Ribble Valley Borough Council
Housing & Development Control

Application no: **3/2022/0082**

Address: **The Old Garage Site Newton Road Dunsop Bridge BB7 3BB**

Proposal: **Redevelopment of the old garage site to provide new building that includes a cafe, community shop, retail unit, post office, community spaces together with a separate store/plant room.**

Client	The Duchy of Lancaster		
Contract	OLD GARAGE SITE Dunsop Bridge		
Drawing title	PROPOSED SITE PLAN & BLOCK PLAN		
Scale	Job No.	Dwg No.	
1:250	KL2887	105	B

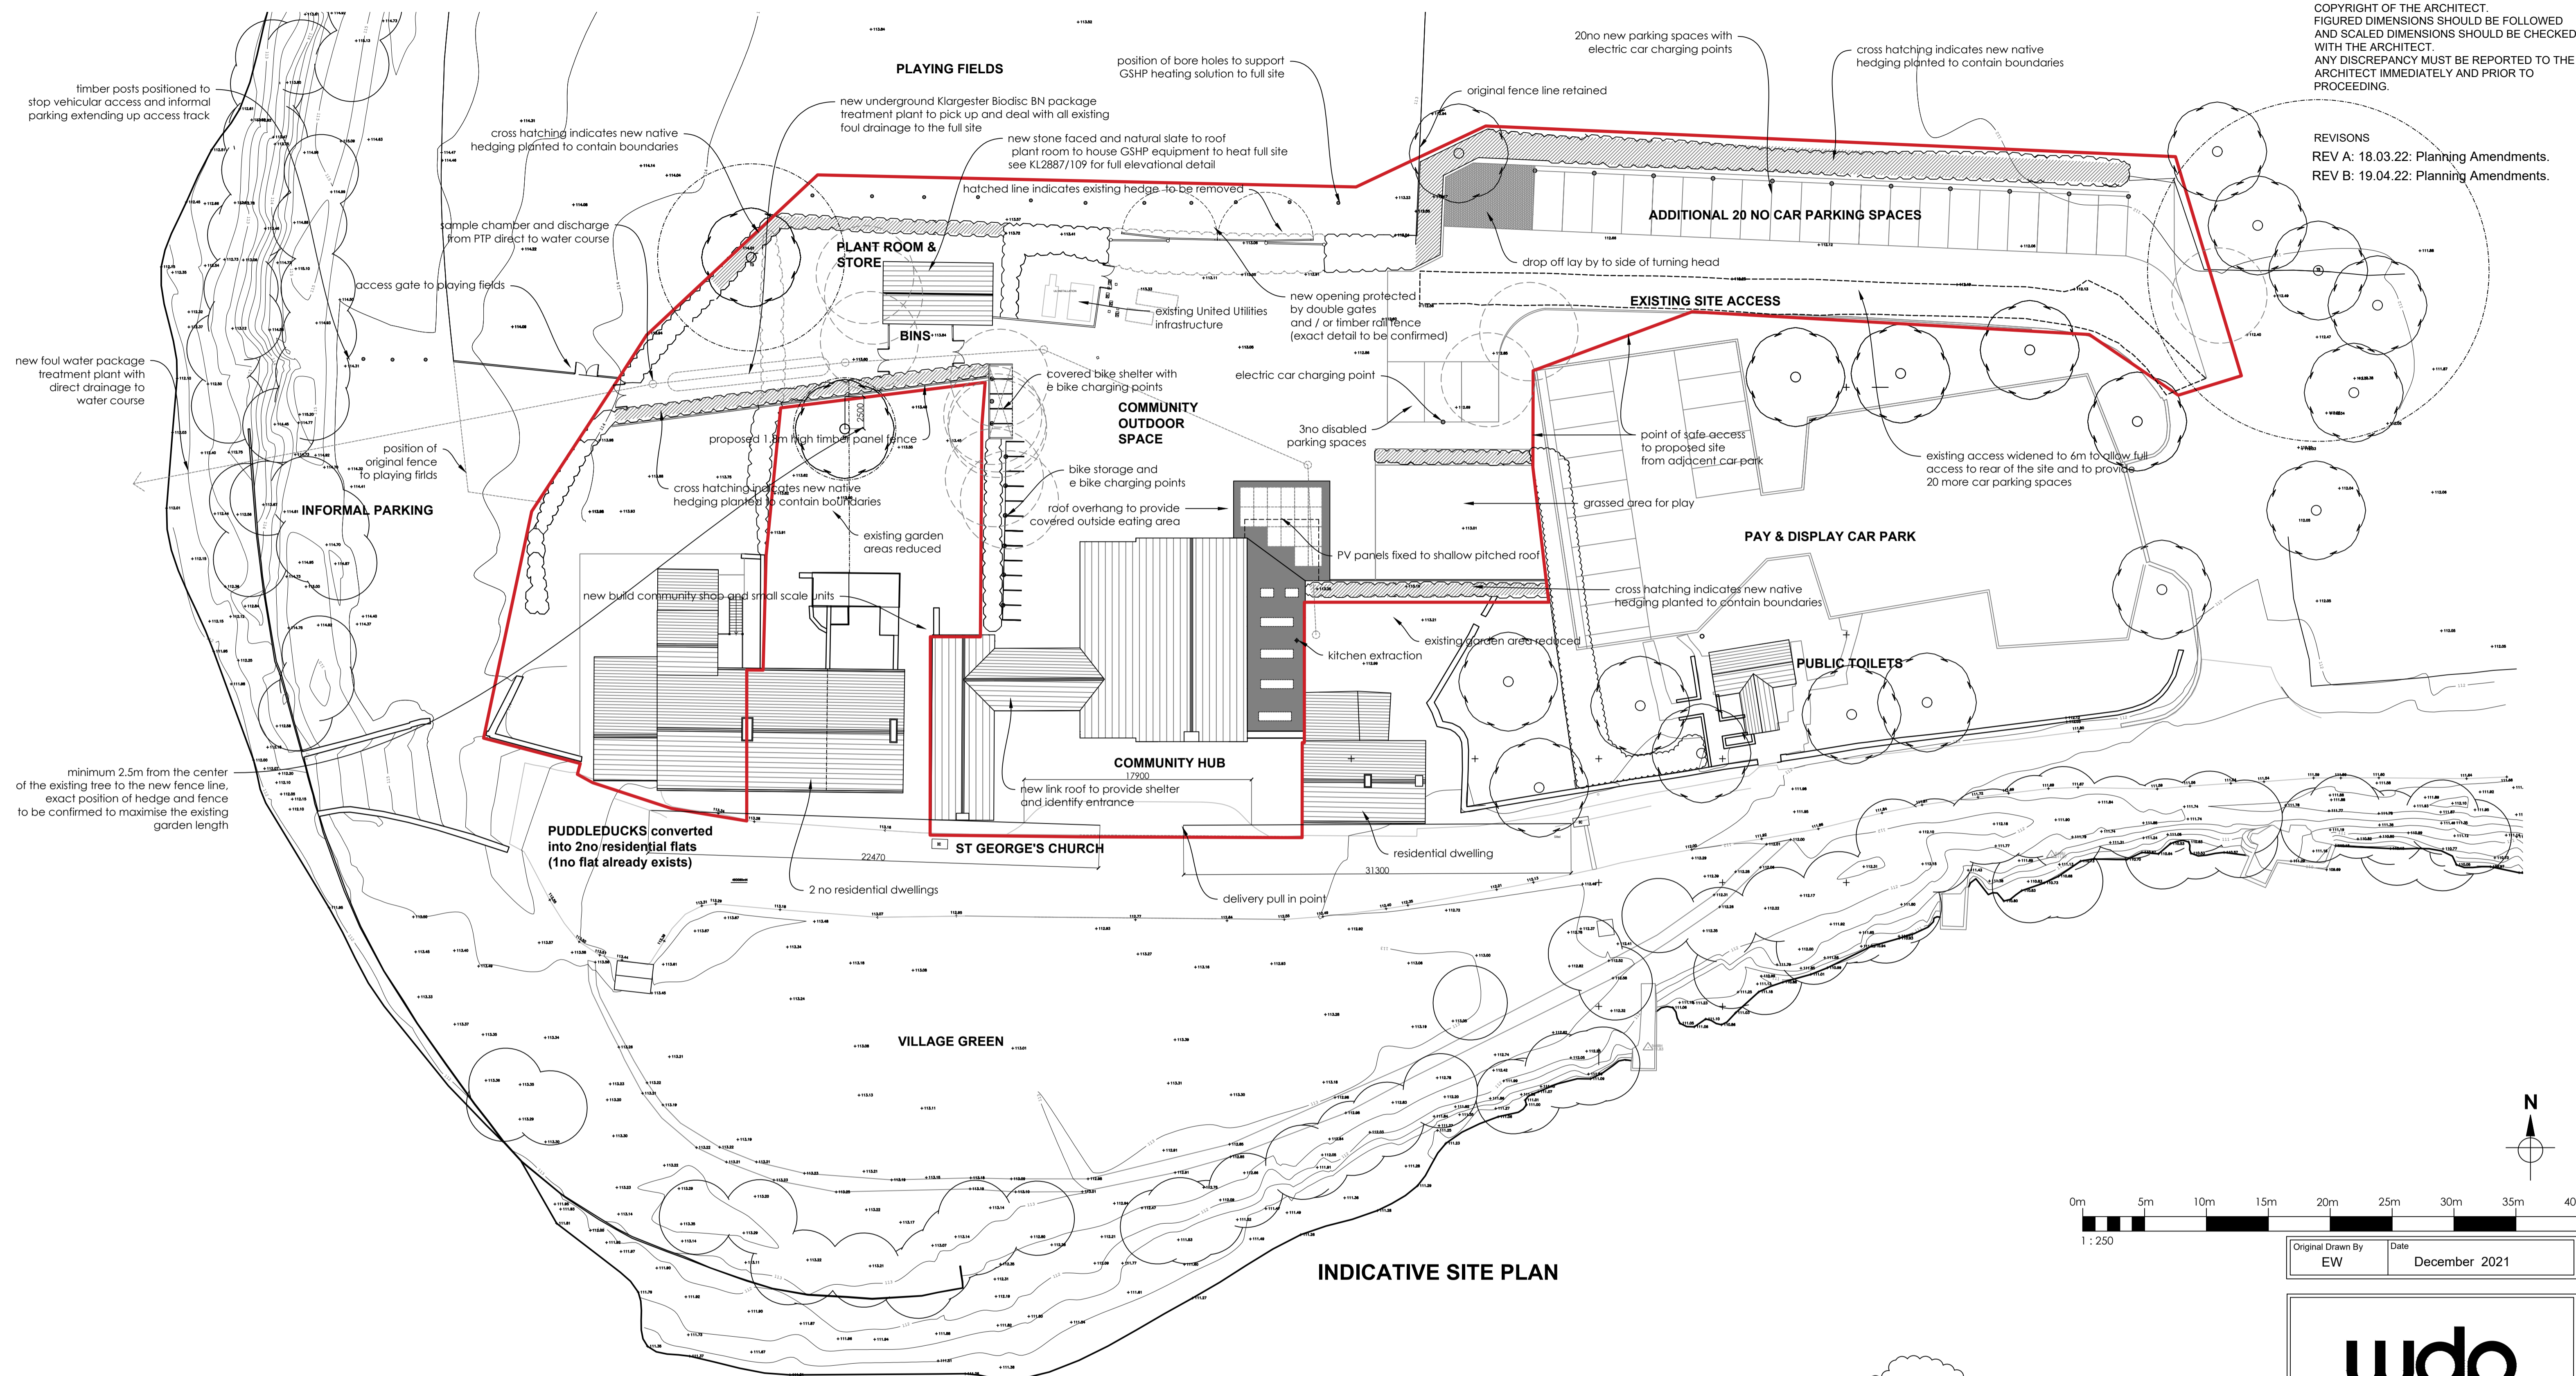
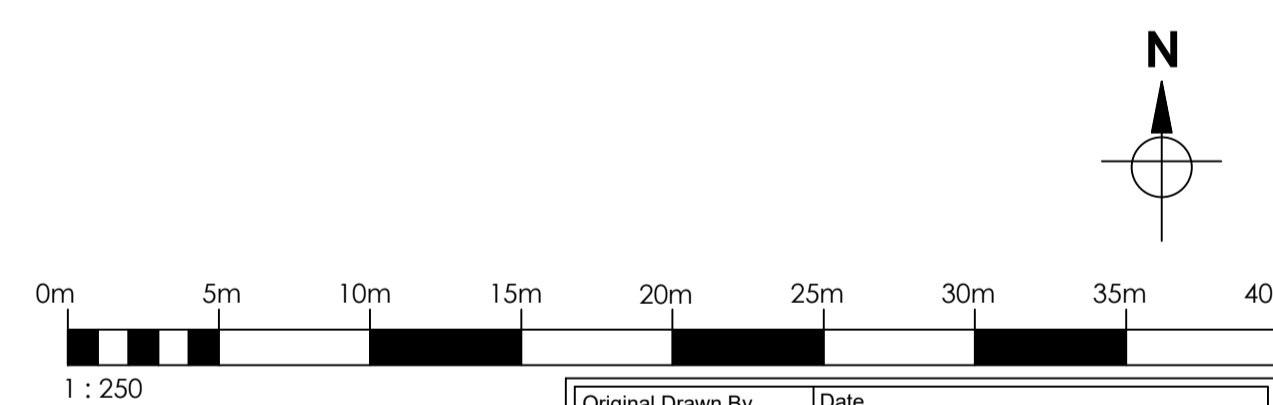
The first access is to the front of the site and as shown on WDP drawing number 105 Rev A titled "Proposed Site Plan and Block Plan," the access will be used as a lay-by/ drop off point for deliveries and for short-staying customers.

The LHA have reviewed the dimensions of the proposed lay-by/ drop off area and are aware that they measure approximately 17.9m in length and 3.6m wide. Therefore, the LHA are aware that 3 vehicles parked in a parallel formation are likely to be able to park in this area at any one time.

However, with the lay-by being the only designated delivery point to the site, the LHA require the drop-off area element to be removed. This is because should a large, delivery vehicle be servicing the site and there are vehicles parked in the lay-by, the

LHA are concerned about where the delivery vehicle will park. This could lead to inappropriate parking by large, delivery vehicles occurring along Newton Road.

Therefore, the LHA request that the drop off area for customers in the lay-by is removed on an amended plan.

The LHA suggest that the drop off area should be relocated to the rear of the site. This could be provided on the proposed car park, where the grass verge and tree is located adjacent to the additional car parking spaces. This way the drop off area will not conflict with the designated service area at the front of the site and there is ample space to provide at least 2 drop off parking spaces.

As already mentioned, the secondary access to the site is provided from the existing Public Car Park leased by Ribble Valley Borough Council. The application is proposing to add 23 additional spaces for the development, as shown on WDP drawing number 105 Rev A titled "Proposed Site Plan and Block Plan."

The LHA have reviewed WDP drawing number 105 Rev A titled "Proposed Site Plan and Block Plan," and are aware that the site will provide 23 car parking spaces which will include 3 disabled bays and multiple electric vehicle charging points. Visitors to the site will also be able to use one of the 39 bays which are located in the Public Car Park.

The LHA also welcome on WDP drawing number 105 Rev A titled "Proposed Site Plan and Block Plan," the introduction of secure cycle parking and electric vehicle charging points.

The LHA request, before they can fully support the application, to relocate the drop-off area from the lay-by. This is because the lay-by will be used as the sole delivery area to the site. Therefore, the LHA request the customer drop-off area to be removed and instead relocated to the rear of the site adjacent to the proposed car parking spaces, as expressed in the "Site Access" section. This should be shown on a revised plan and once an amended plan is submitted the LHA will have no objection to the proposal subject to conditions.
